Re: Objection to retrospective planning application FP/66/26/PL

Site: Rabbit Island, rear of 84 Brooks Lane, Bognor Regis, PO22 8DN

I am writing to formally object to retrospective planning application FP/66/26/PL, concerning the retention of an existing agricultural barn previously approved under FP/106/23/AG, with a total roof height of 4.2 metres compared with the 2.9 metres permitted.

Drawing: Elevations and floor plan

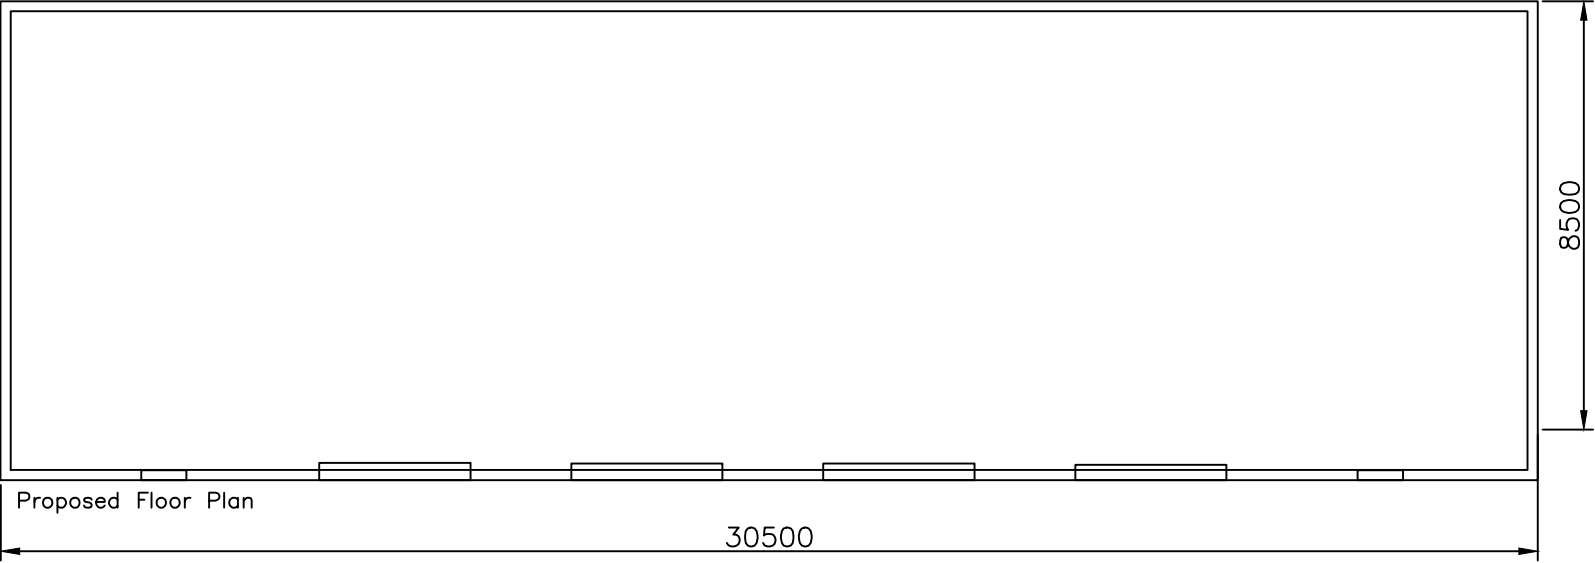
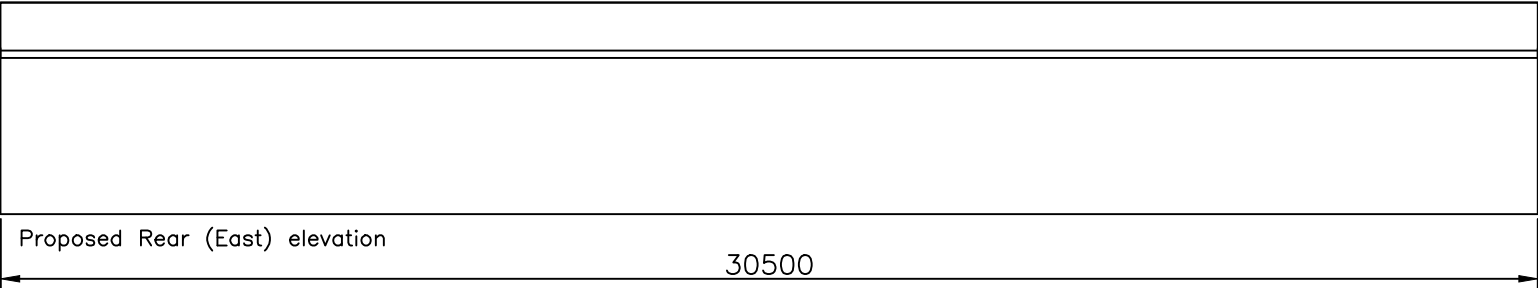
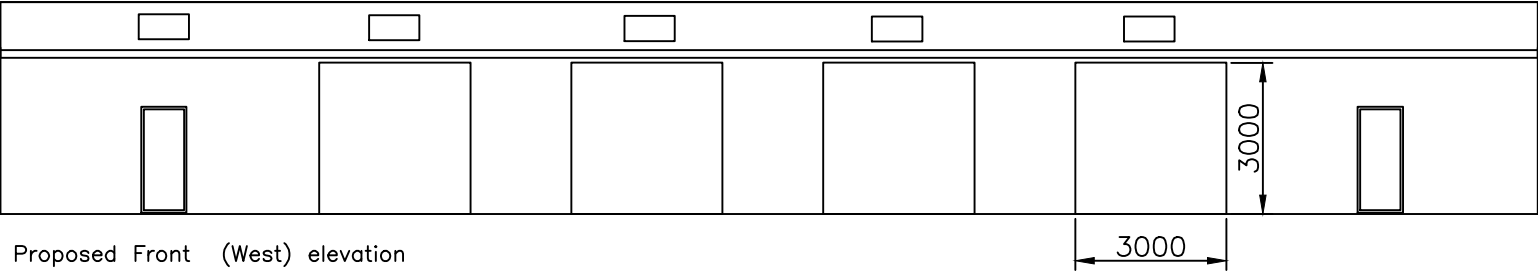
The barn is highly visible from the adjacent public footpath. Its increased height creates a dominant and visually intrusive form that does not respect the scale or character of the surrounding open countryside.

- The barn is approximately 120 metres from Bognor Gliding Club and exceeds the 3 metre height limit that applies near an airfield.
- Approximately 3 of the 8 hectares of land are being used for recreational purposes rather than agricultural grazing.

- The stated hay storage requirement is minimal in relation to the size of the barn. Approximately 38 cubic metres of hay would occupy only about 8.1% of the building volume as constructed, or 11.8% of the originally permitted volume, assuming a standard footprint of 111.5 square metres (1,200 sq ft).

The unauthorised 4.2 metre structure fails to comply with local and national planning policies. I respectfully request that the Council refuse this application and take enforcement action to remove the building or reduce it to the permitted dimensions.

We also formally request that Planning Enforcement issue an Enforcement Notice under Section 172 of the Town and Country Planning Act 1990 to secure the removal of the unauthorised structure or its reduction to the legally permitted limits.
